Mark E. Jones, PE
Structural Engineering and Design

Ref: Site Observations and Analysis
93 Warner Hill Ct.
Fuquay-Varina, NC 27526
Permit No. SFD2024-0080
Project No. 24-141

The plans for the above referenced site were reviewed on September 23, 2024 for the following items:

1. Builder wishes to eliminate columns at kitchen/great room/foyer.

FIRST FLOOR PLAN

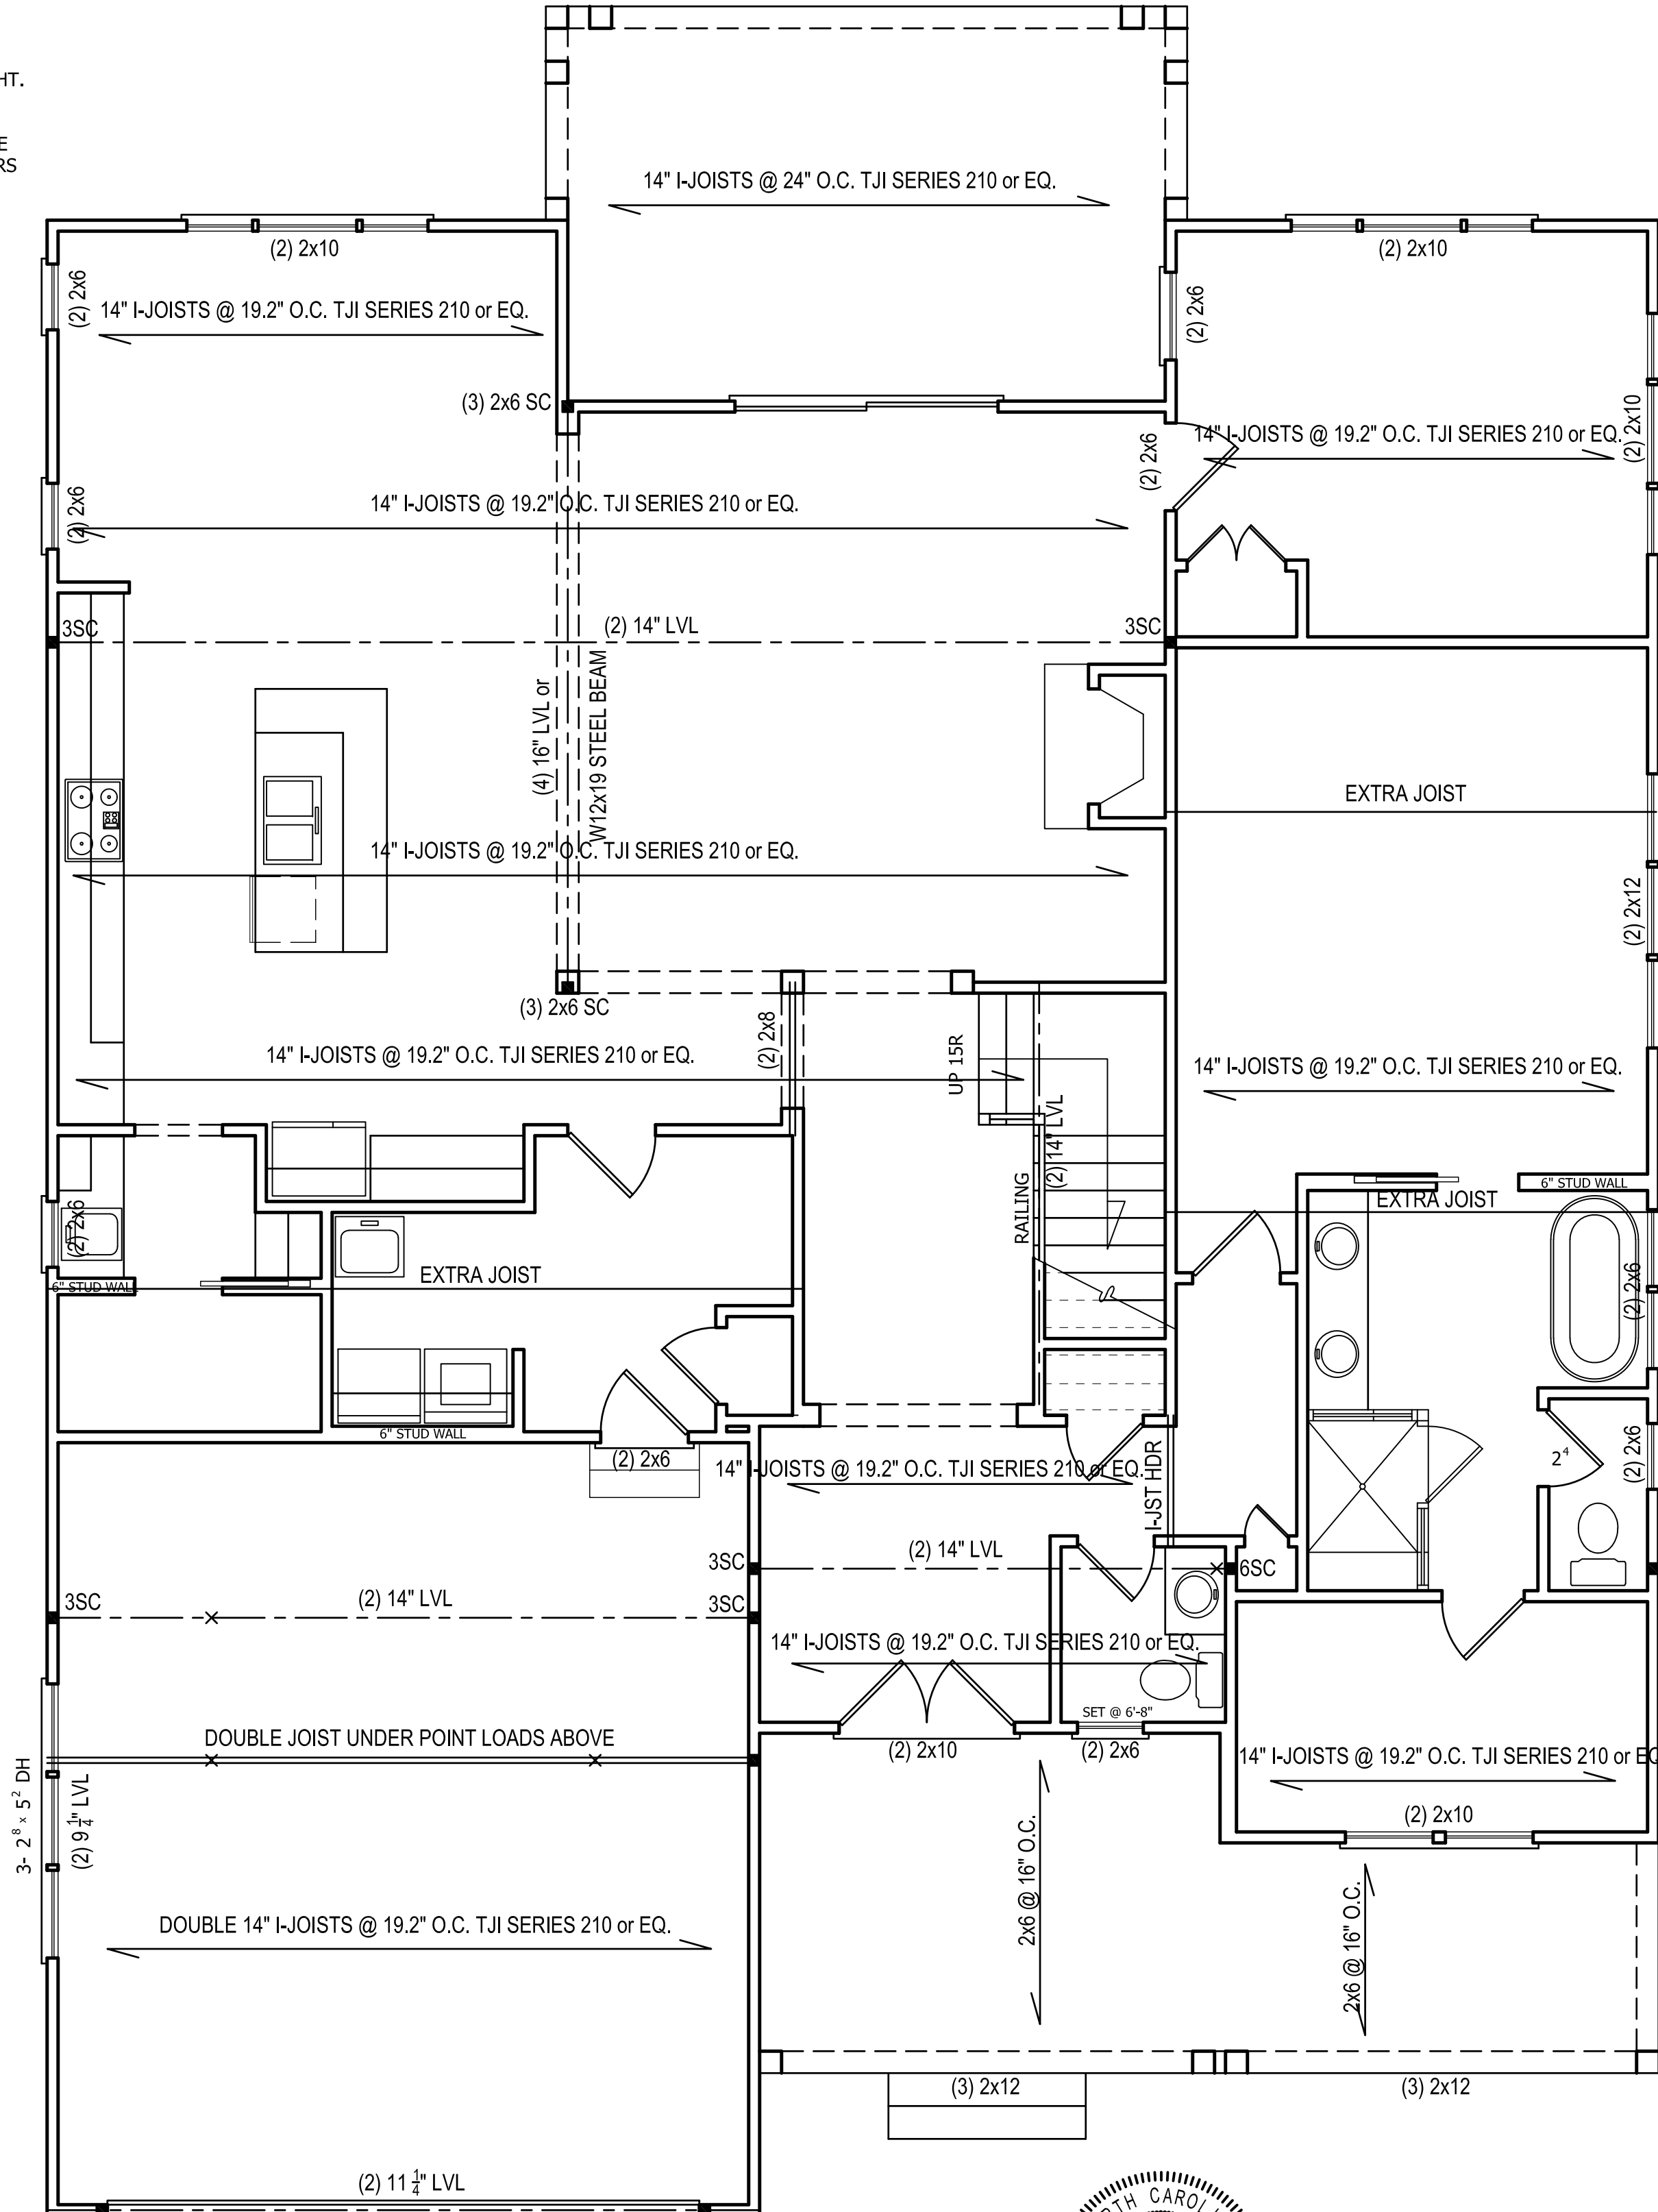
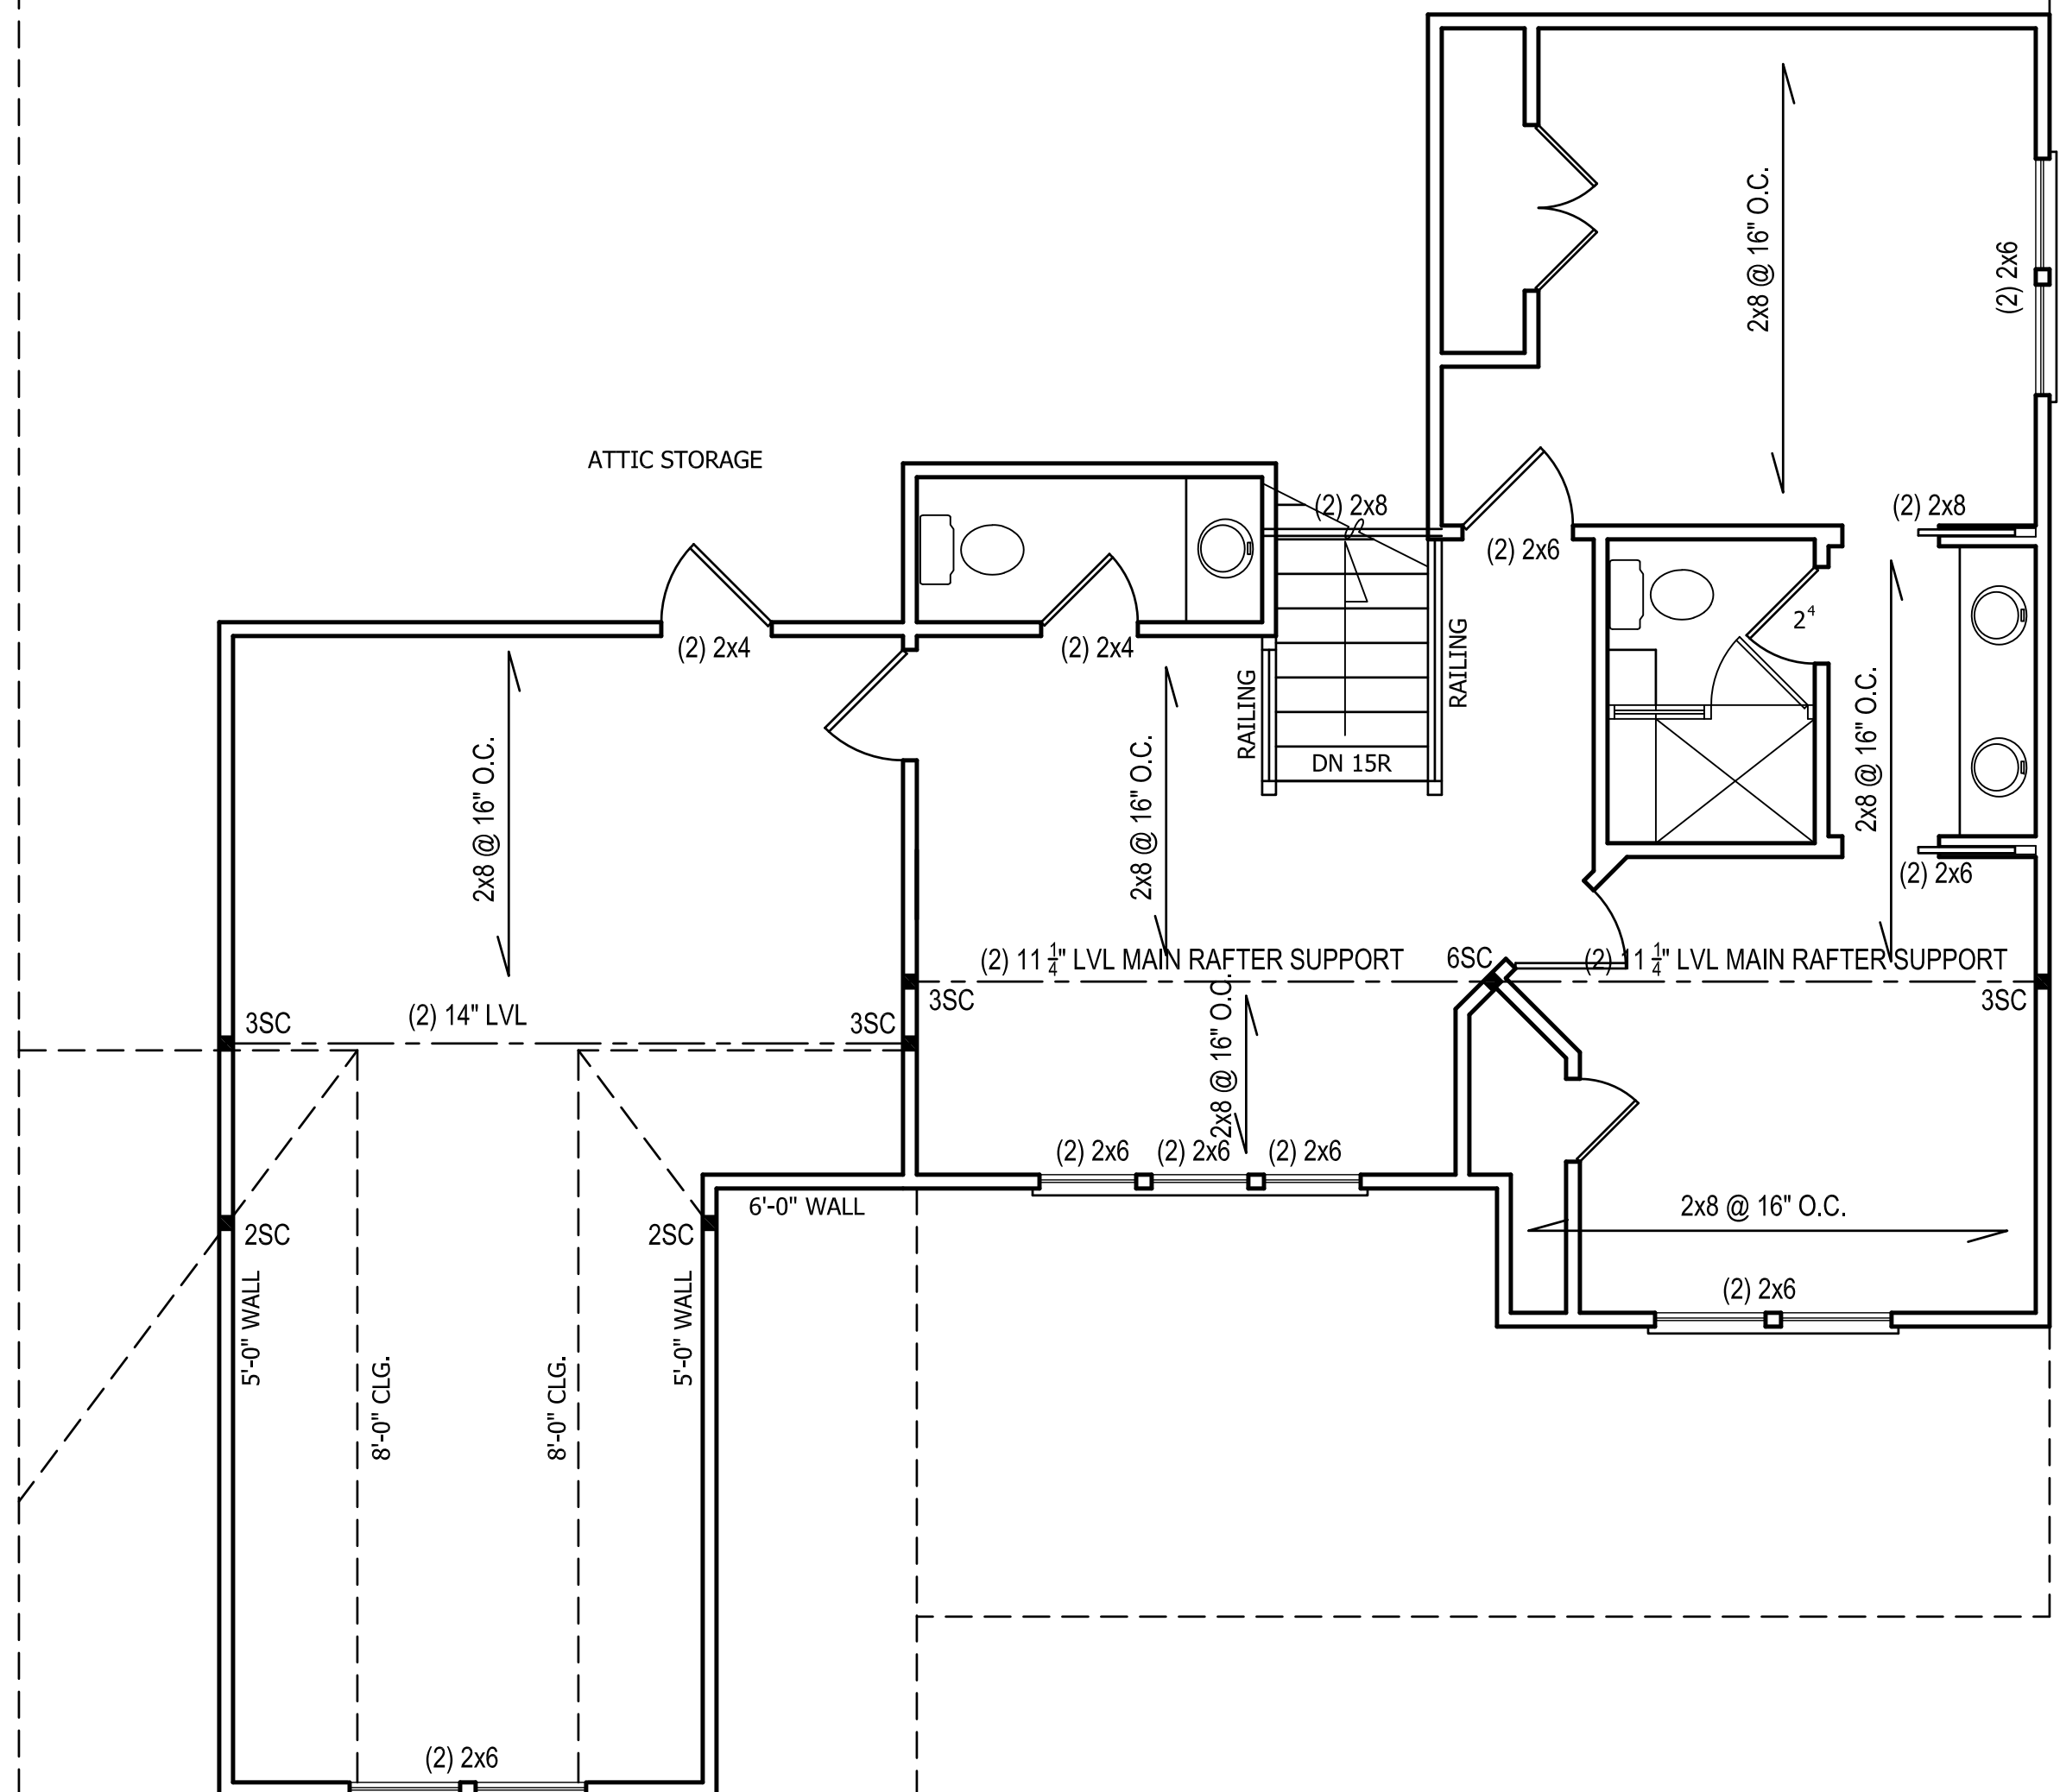
1. To eliminate the columns between the kitchen and the great room, the beam will need to extend forward to the laundry room. A 3-ply 24" LVL will be required for this span. Also, a new pier will be needed to directly support the front end of the beam. The attached drawing shows the changes in the first floor ceiling.
